**Consultation Response from KC,
Highways Development Management****2023/93495 Land rear of, Yorkshire House, South Street, Dewsbury, WF13 1JT****Erection of hotel (within a Conservation Area)****Date Responded: 22-10-2024.****Responding Officer: Mark Berry.****Responding Ref: 15-10-2024.**

This application seeks approval to the erection of a hotel at land rear of, Yorkshire House, South Street, Dewsbury

DRAWING TITLE
VEHICLE TRACKING

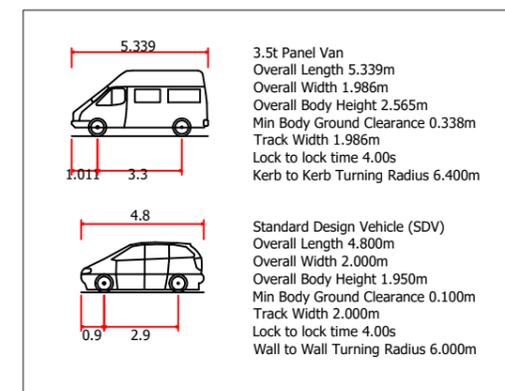
HDM do however have concerns regarding the potential for servicing of the site by larger vehicles. Whilst the TS refers to servicing of the hotel being via smaller vehicles this cannot be guaranteed and HDM would therefore ask that the applicants demonstrate that, if necessary, a larger vehicle can reverse into the site and that servicing by larger vehicles can be undertaken without obstructing School Street.

Swept paths analysis should therefore be provided to demonstrate that an 11.85m long refuse vehicle can reverse into the site and that the site can be potentially serviced by larger vehicles without obstructing the flow of traffic along South Street.
